Please treat as substitute plans

From: Maija Korpak <[REDACTED]>
Sent: 01 October 2019 12:36
To: Anita Gardner <[REDACTED]>
Subject: RE: LU/174/19/PL 2a Norfolk Road Littlehampton

Project	2A NORFOLK ROAD	
Status	PLANNING	
Drawing	SIDE ELEVATION (SOUTH)	
Drwg No :	Scale :	Date :
381_20_233	1:50@A3	27/04/19

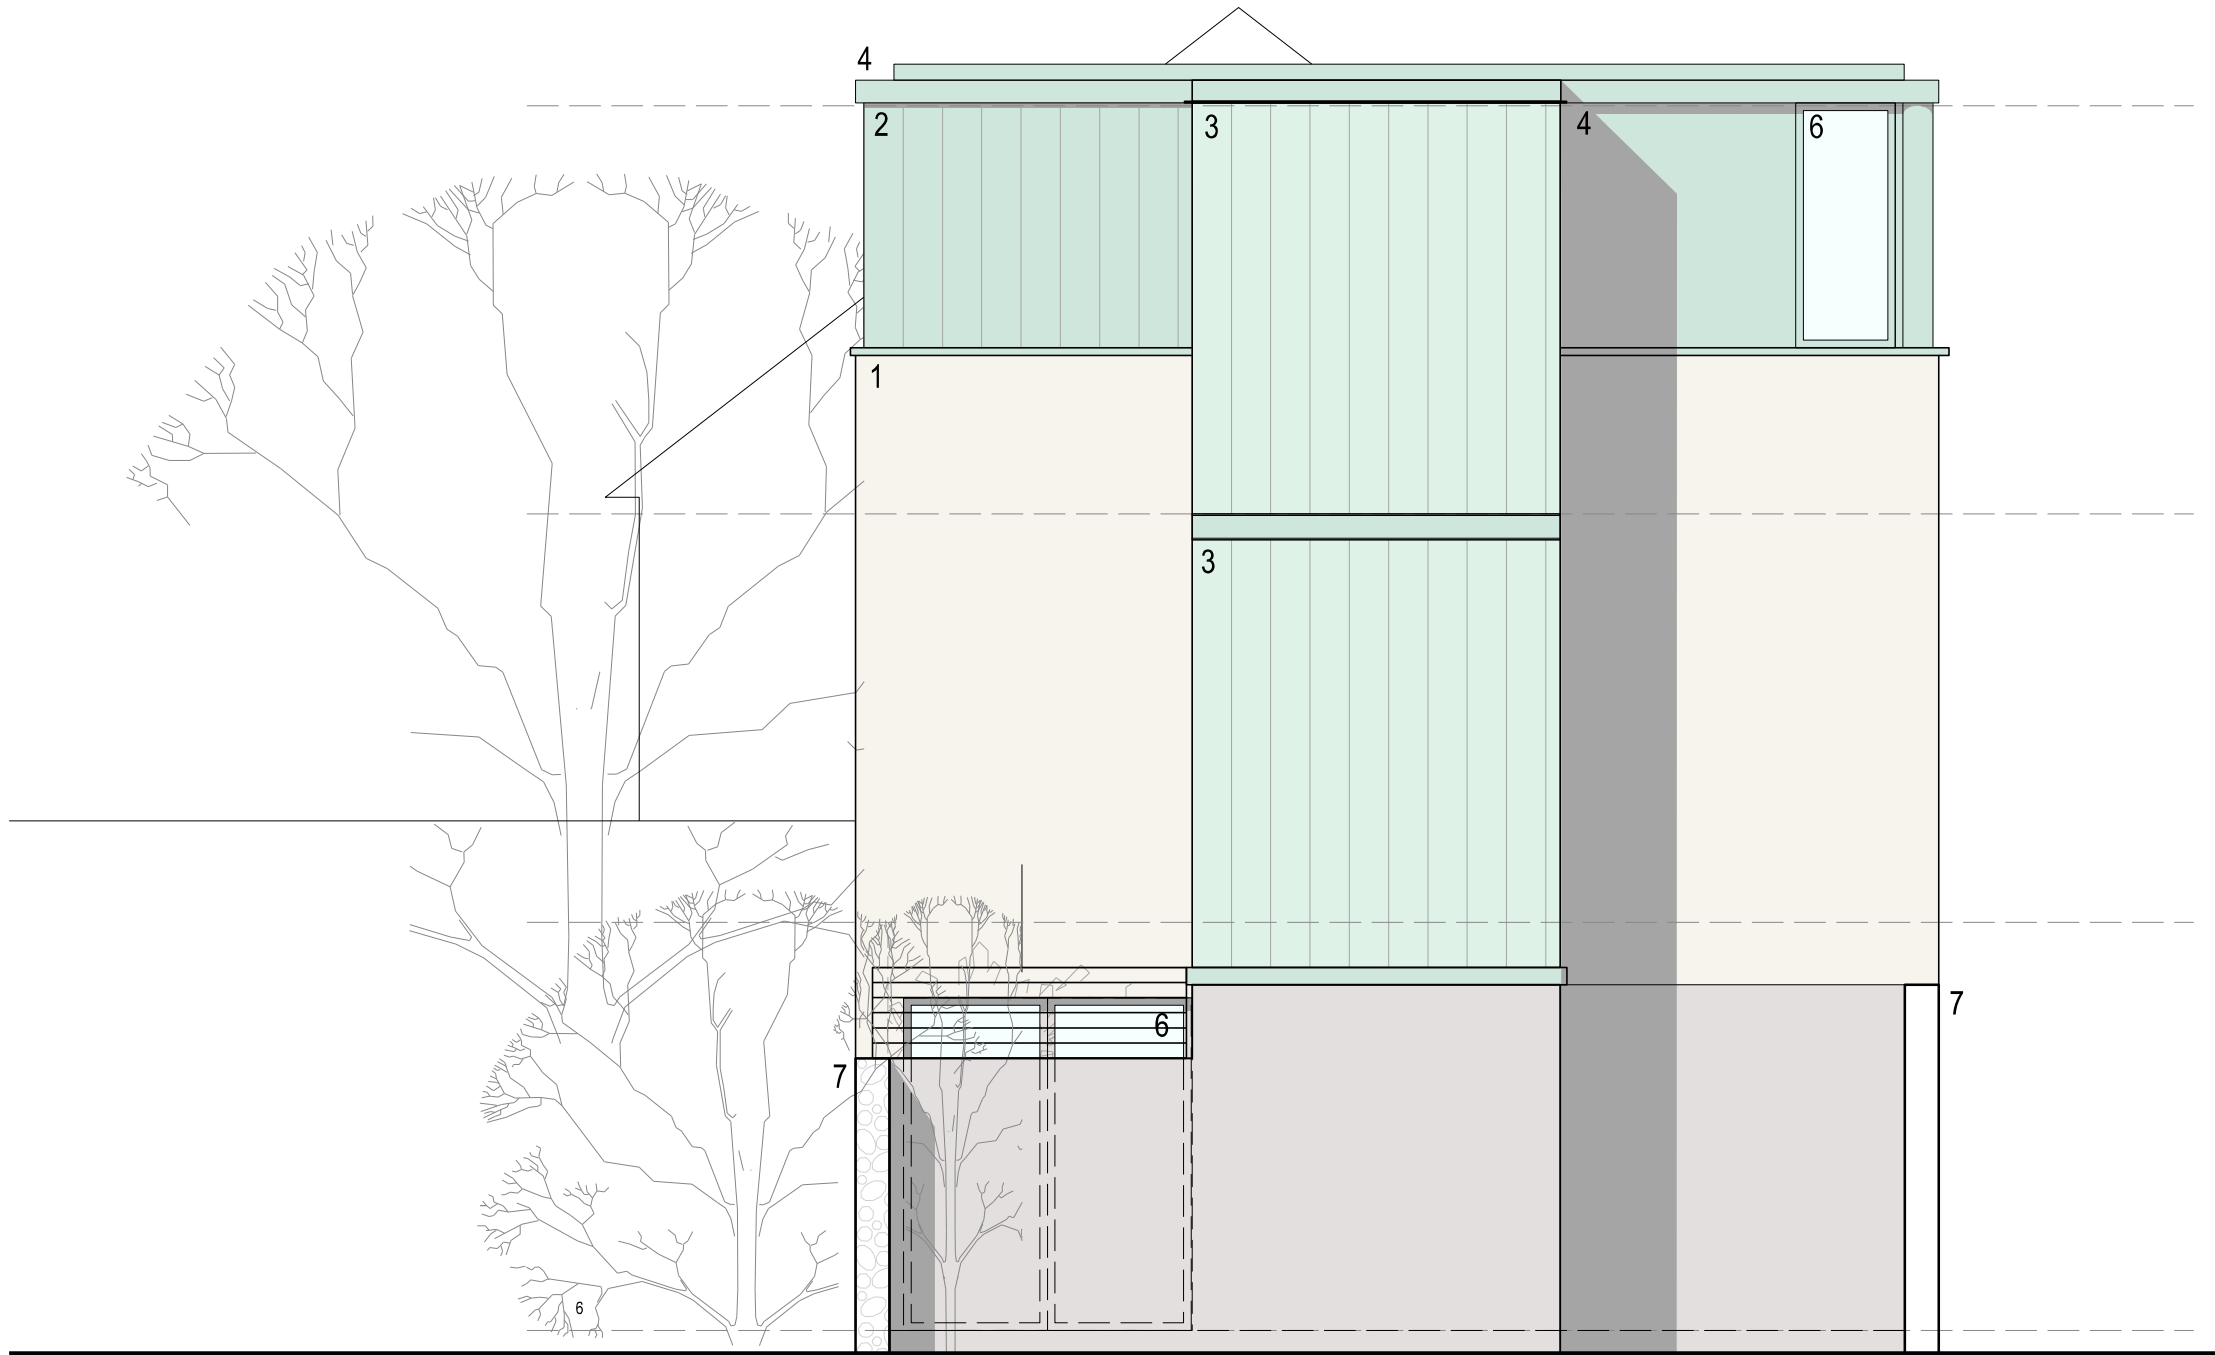
Your application report is being worked on by a colleague. It has come to light that the western and southern elevations have been annotated with a scale of 1:100 which should be 1:50. Please can you let me have substitute plans with the correct scale? In the meantime I would hope that the report will be completed shortly and passed

Please find attached drawings with amended scale note as requested.
